Re: Planning Application No: 3/2021/0969
Location: 20 Wellbrow Drive, Longridge, PR3 3TB

Your letter dated 06.10.2021 was the first I'd heard about this proposed re-application for the huge front dormer by Mr Howson, [REDACTED] and new plans for a much bigger "porch". I'm writing to express my concerns on the following grounds:

## PART FIRST FLOOR / LOFT PLAN

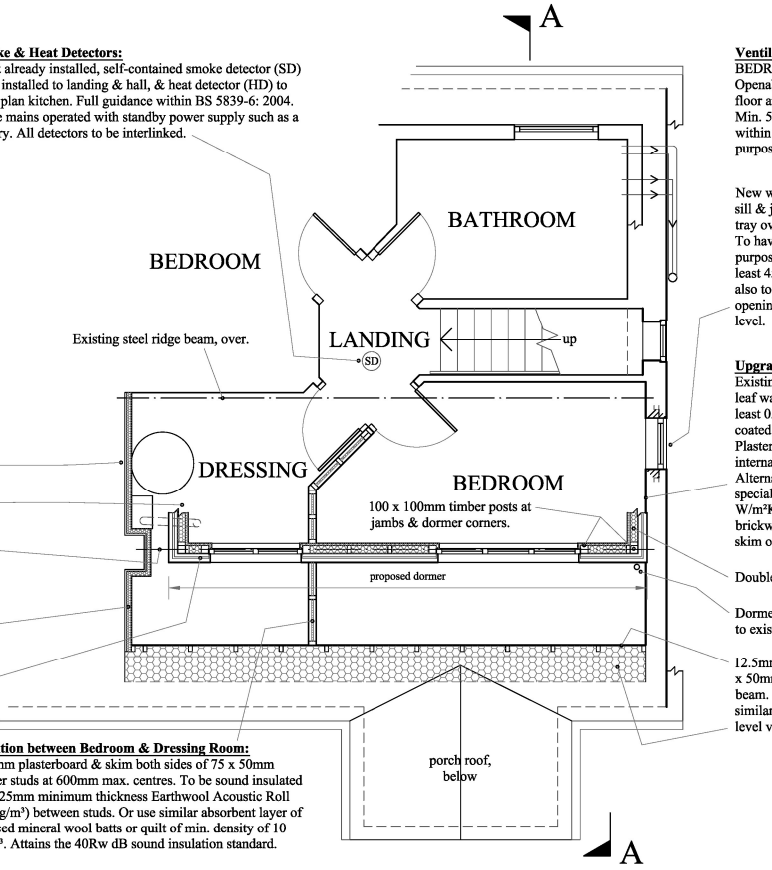
- RVBC have previously declined 2 applications for this front loft conversion because of its sheer size and lack of proportion or sympathy for the original design of our adjoining bungalows or the others in our street.
- Precise measurements have been omitted on all these latest plans. Only measurement scales appear, not aligned with the diagrams. [REDACTED]

[REDACTED] The proposed front dormer appears not much smaller, nearly half of the descending roof space, [REDACTED] different from all other bungalows on our road. [REDACTED]

SIDE (SOUTH WEST FACING) ELEVATION *Proposed*

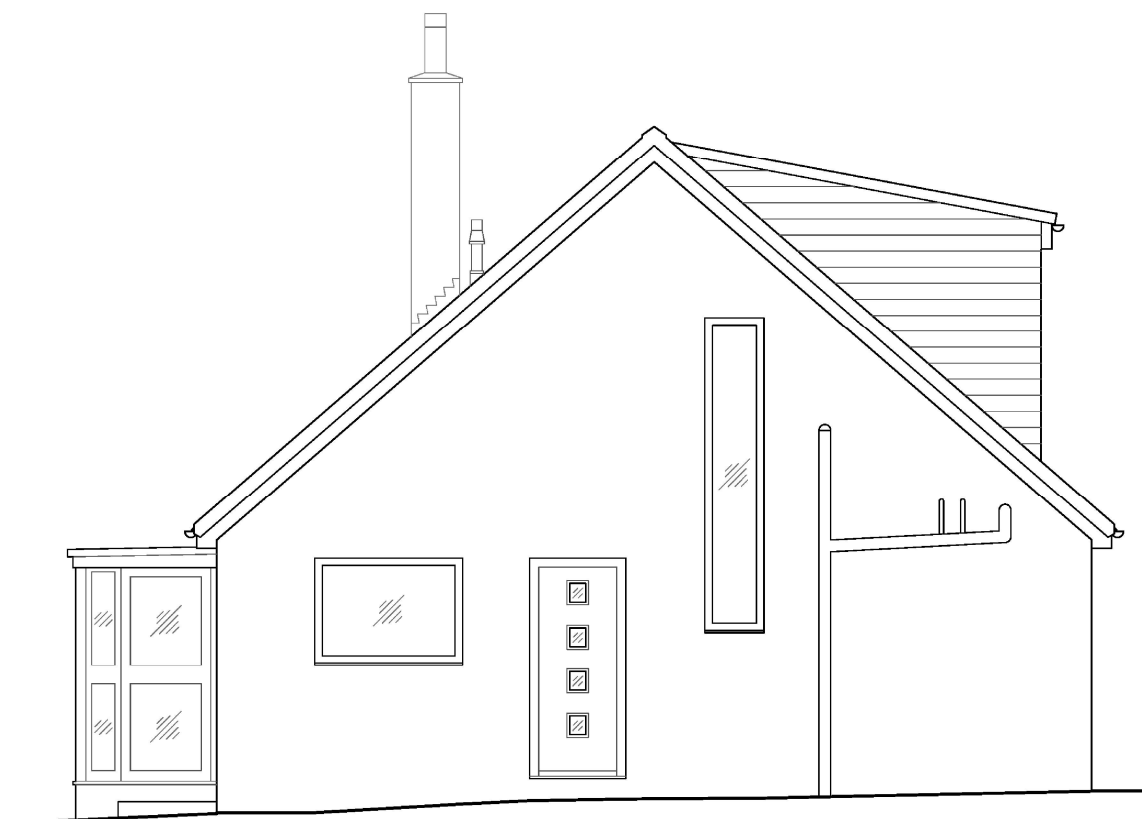
- The only measurements given are for the redesigned brick "porch": **"approx" 2.570 m x "approx" 1.575 m.** [REDACTED] of 1.80 m x 1.30 m, and together with the raised pitched roof ascending into the main roof above the eaves, is of a proportion more akin to a front extension wing. Even on the diagram, the "porch" extension is proportionate to two thirds of a downstairs room, or a quarter of the depth of the house, [REDACTED]
